SSD 6011 - Mixed use residential development within the South West Plot

Submission by:

Kim Seeto

29 July 2013

## Winter Solstice (21<sup>st</sup> June)

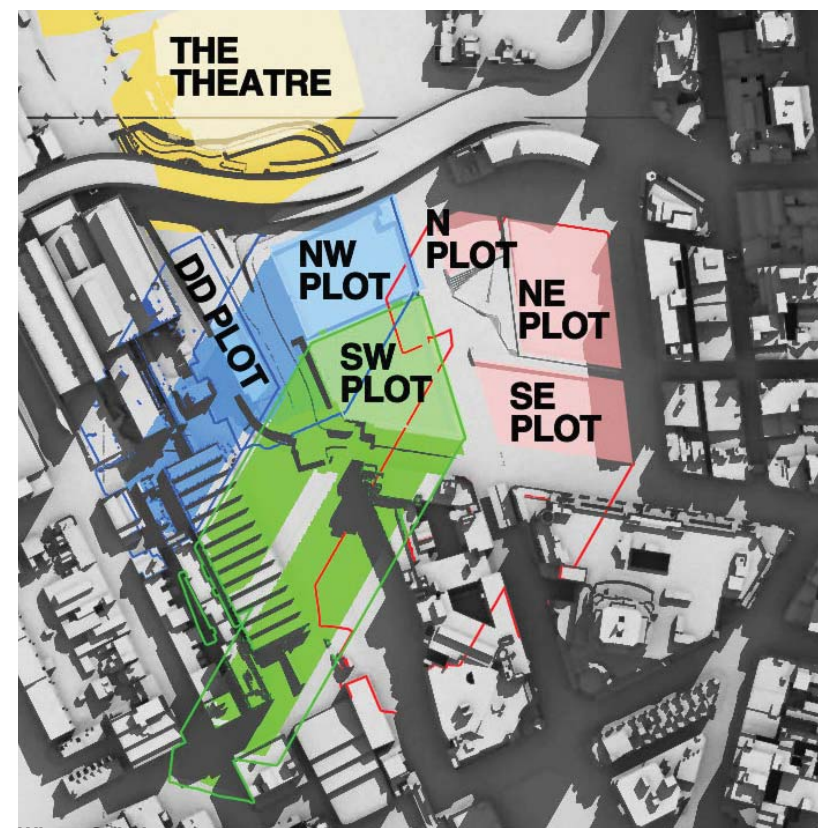
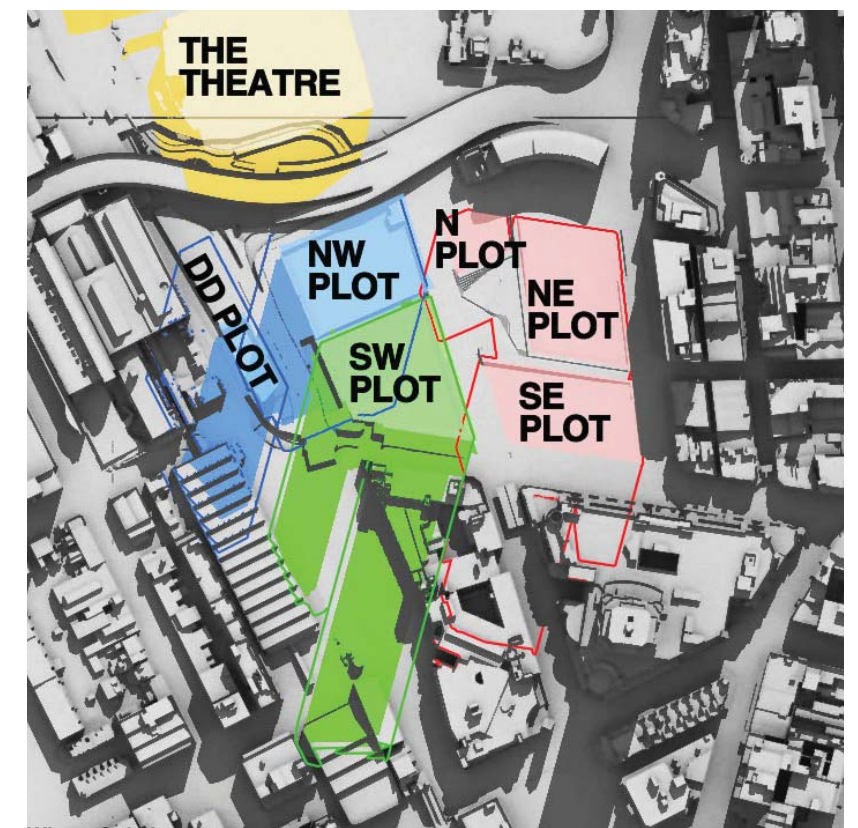
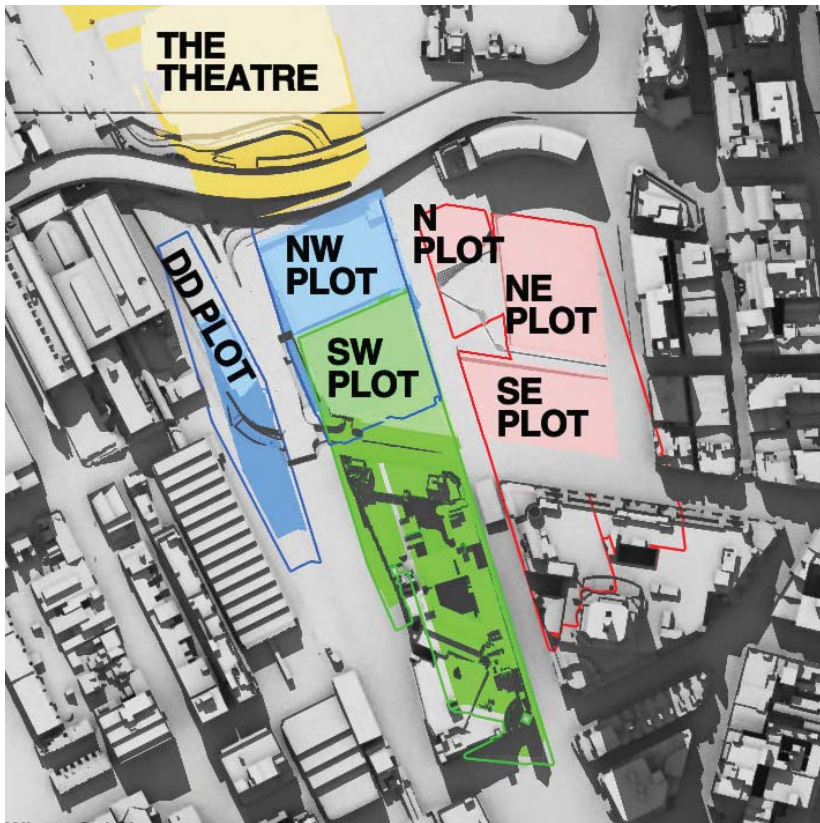
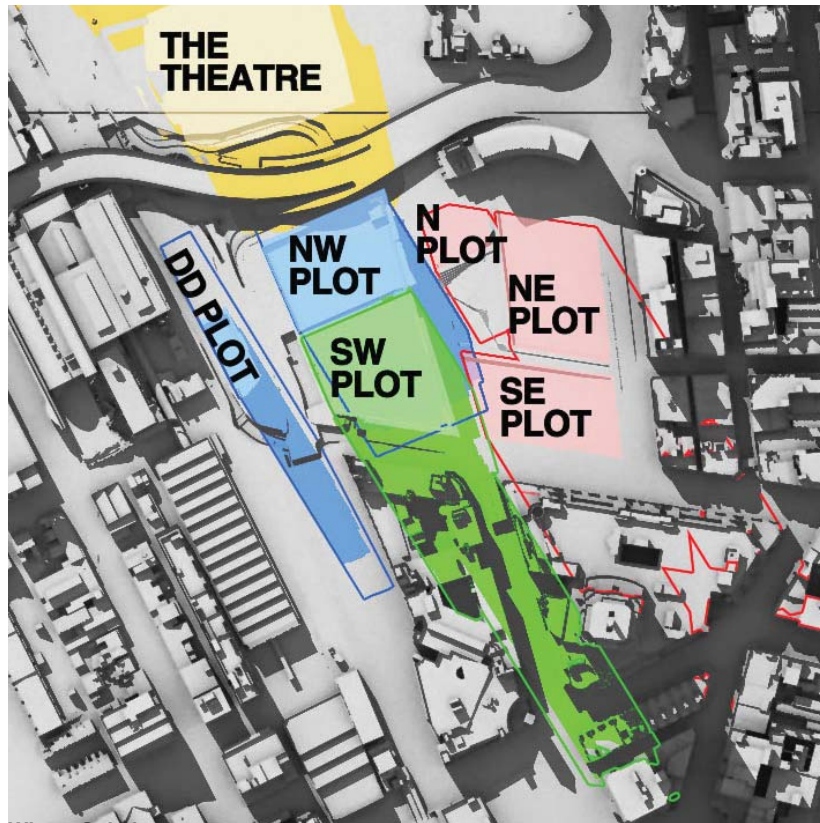
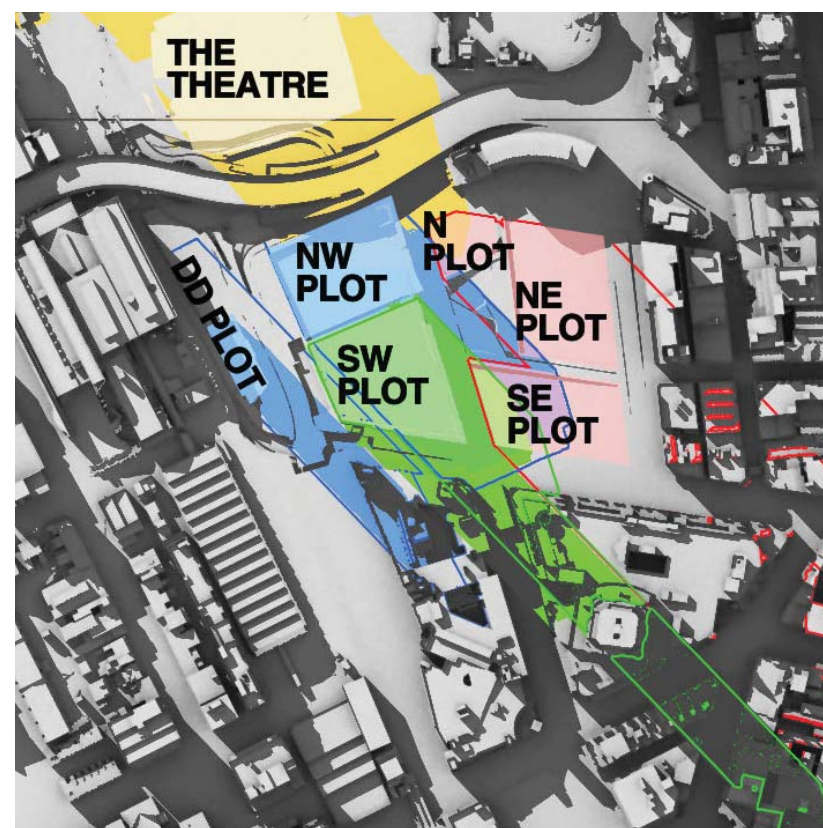
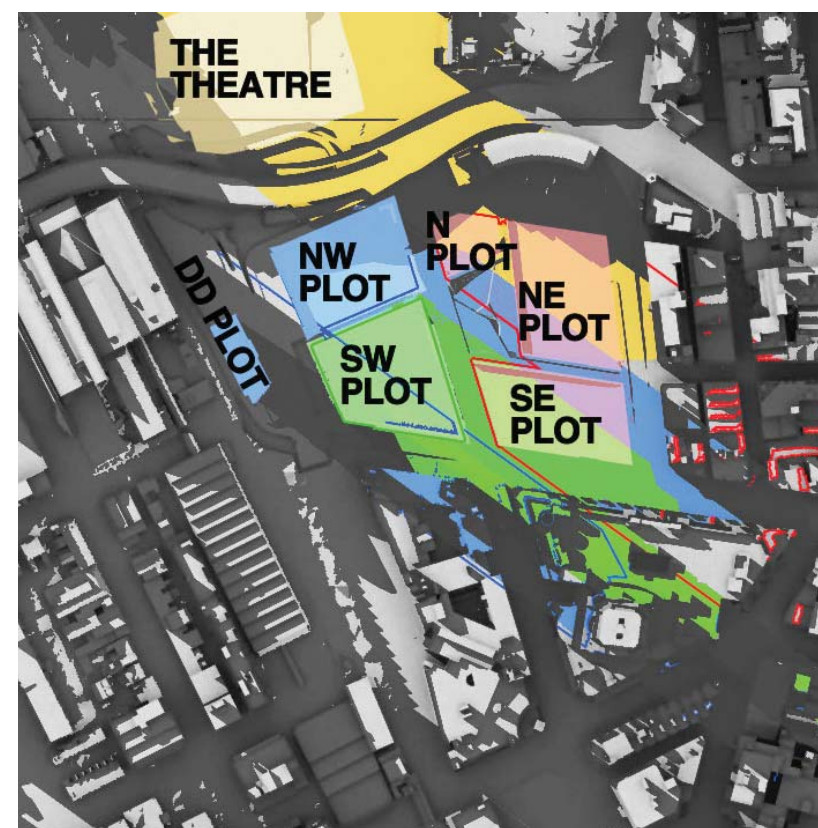
At 9am, 10am and 11am the west façade is totally in shadow due to other parts of The Peak building itself.

At 12pm there is still substantial existing shadowing on the west façade caused by the irregular shape of the west facade.

At 1pm the existing shadowing has been substantially removed, but not totally removed.

It can be concluded that some single aspect apartments on the west façade and some south-west dual aspect corner apartments currently receive less than 2 hours direct sunlight to habitable rooms and 50% of the private open space between 9am and 3pm on 21 June.

By 2pm the existing shadowing has been totally removed, but that is too late to achieve two hours of direct sunlight before 3pm.

At 9am, 10am and 11am the west façade is totally in shadow due to other parts of The Peak building itself.

At 12pm there is still substantial existing shadowing on the west façade caused by the irregular shape of the west facade.

At 1pm the existing shadowing has been substantially, although not entirely, removed. However, overshadowing of lower levels of the west façade by the concept proposal parameter plan shadows for the N,NE and SE plots has already started.

By 2pm the existing shadowing has been totally removed. However, overshadowing of the west façade by the SSDA4 and SSDA5 buildings has appeared and risen further up the west façade than the concept proposal parameter plan shadows for the N,NE and SE plots, which is still present.

At 3pm, the proponent states correctly that 45-45% of the western façade is overshadowed by the SSDA4 and SSDA5 buildings.

It can be concluded that, as a result of combination of the proposed development with existing shadowing of the west façade, some single aspect apartments on the west façade and the south-west dual aspect corner apartments which currently receive less than 2 hours direct sunlight to habitable rooms and 50% of the private open space between 9am and 3pm on 21 June will suffer additional overshadowing. It is beyond our skills to count the number of such apartments. We note that the proponent has made no attempt to do so.
